City of Albuquerque
Stormwater Construction Site
Inspection Report

Project Name and Location	Cool Springs Trampoline Park San Mateo & McLeod		
Site Contact Name & Agency	Dennis, Don Guarienti Wilger Enterprises	ESC File No. NPDES ID No.	F17E095B
Date of Inspection	12-12-18	Start/End Time	9:40/10:06
COA Inspector Name	Curtis Cherne, Stormwater Quality		
Describe Present Phase of Construction	paving, landscaping		
Type of Inspection:	<input checked="" type="radio"/> Regular • During storm event • Post-storm event (> 0.25 inch) • 311 / Complaint Response • Follow-Up

Erosion Sediment Control Plan

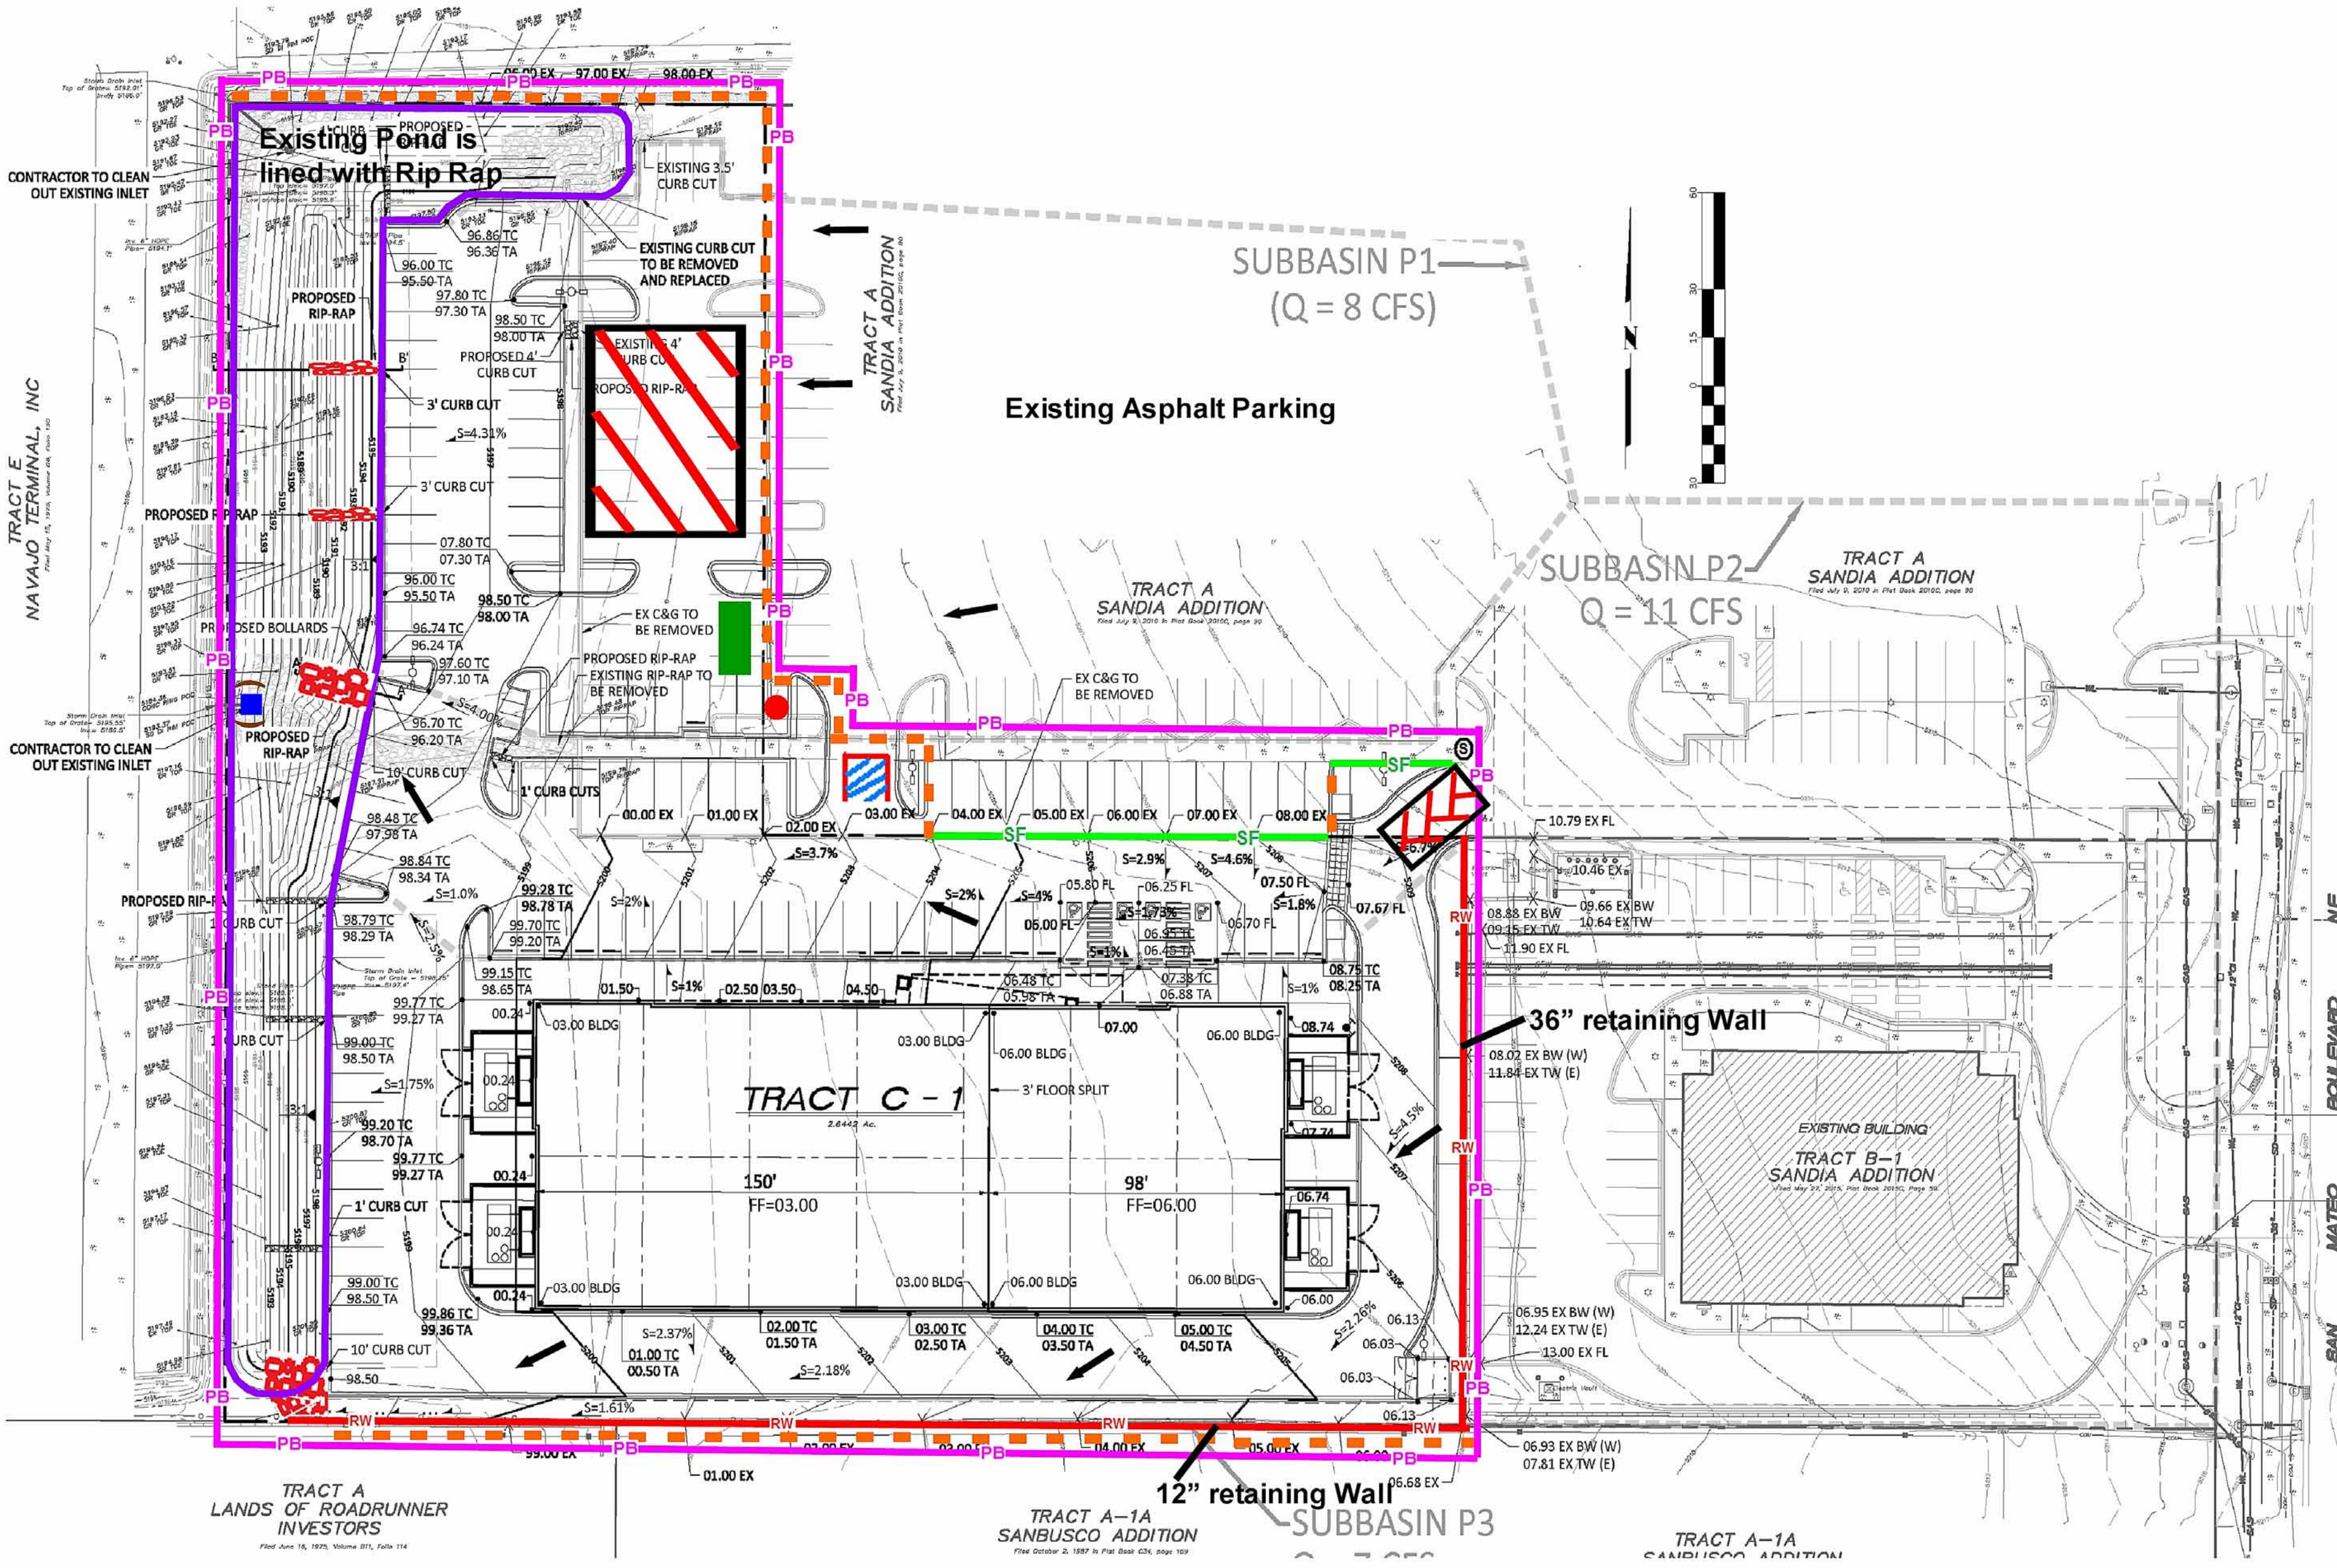
CGP ¹ Section	BMP / Activity	Maintenance or Corrective Action Required	Location and Notes
1.5	Post a Notice	✓	not posted
2.2.1	Provide and maintain Natural buffer when Waters of the US < 50 ft		
2.2.3	Sediment control along any perimeter		
2.2.3	Sediment control along any perimeter		
2.2.3	Sediment control along any perimeter		
2.2.3	Sediment control along any perimeter		
2.2.3	Sediment control along any perimeter		
2.2.3	Sediment control along any perimeter		
2.2.3	Sediment control along any perimeter		
2.2.4	Minimize sediment track-out
